**Harnett County**  
420 McKinney Pkwy  
LILLINGTON, NC 27546  
Phone:  
Fax:

**SUBJECT: BRES2103-0013**  
**BUILDING RESIDENTIAL**

Here are the results of all Inspections located at **104 PAULUS LN:**

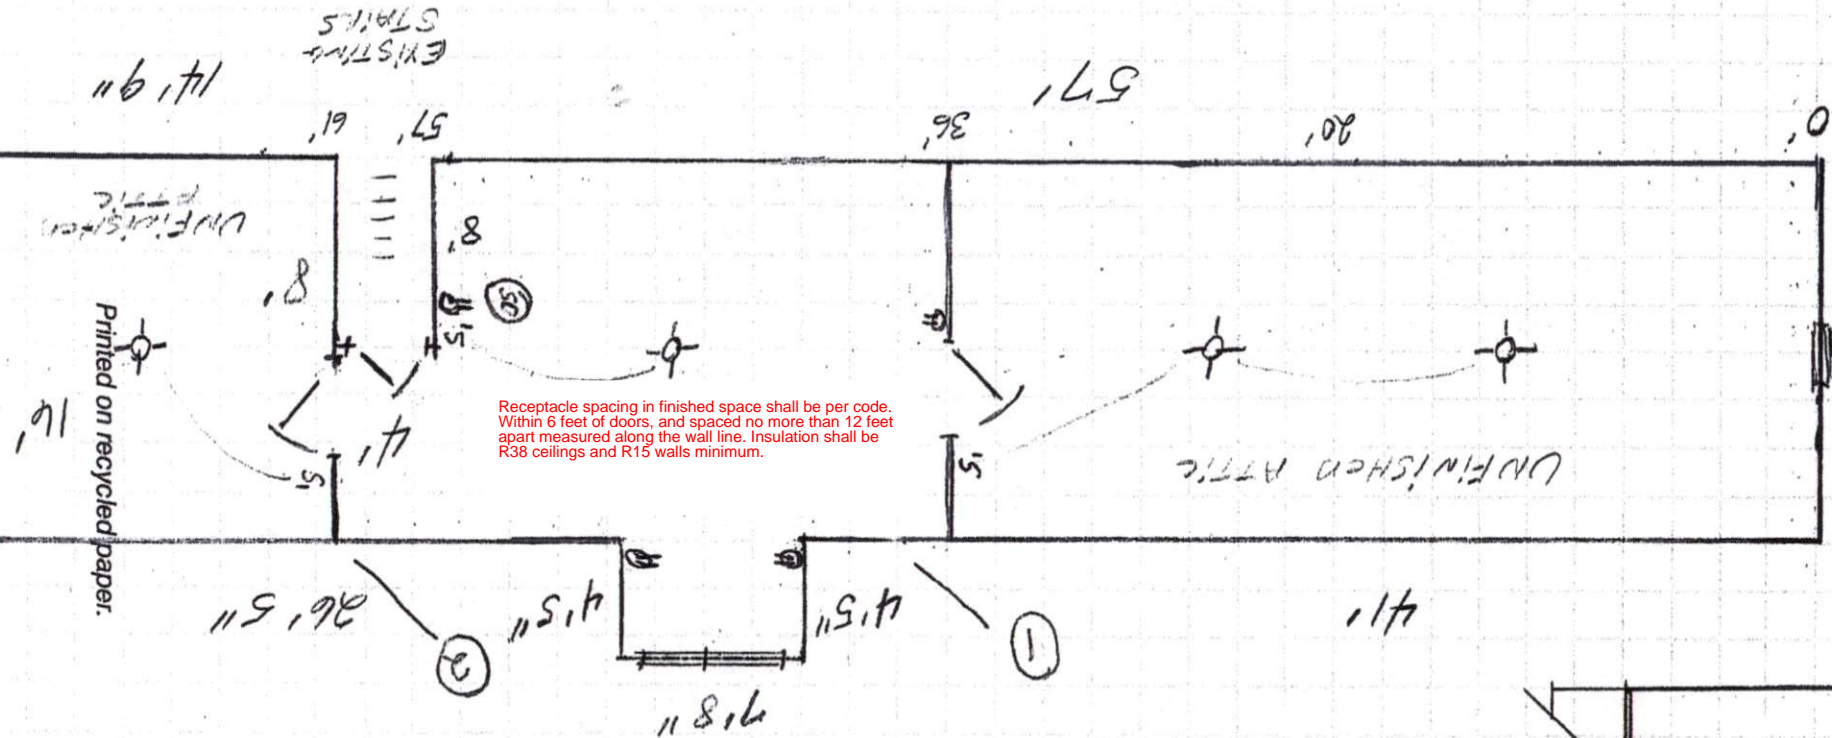
Inspection Type: ROUGH IN  
Scheduled Date/Time: 6/29/2021  
Completed Date/Time: 6/29/2021  
Inspector: Steven Gazlay  
Result: APPROVED W/EXC  
Remarks:  
Notes: Missing air barriers at knee walls.
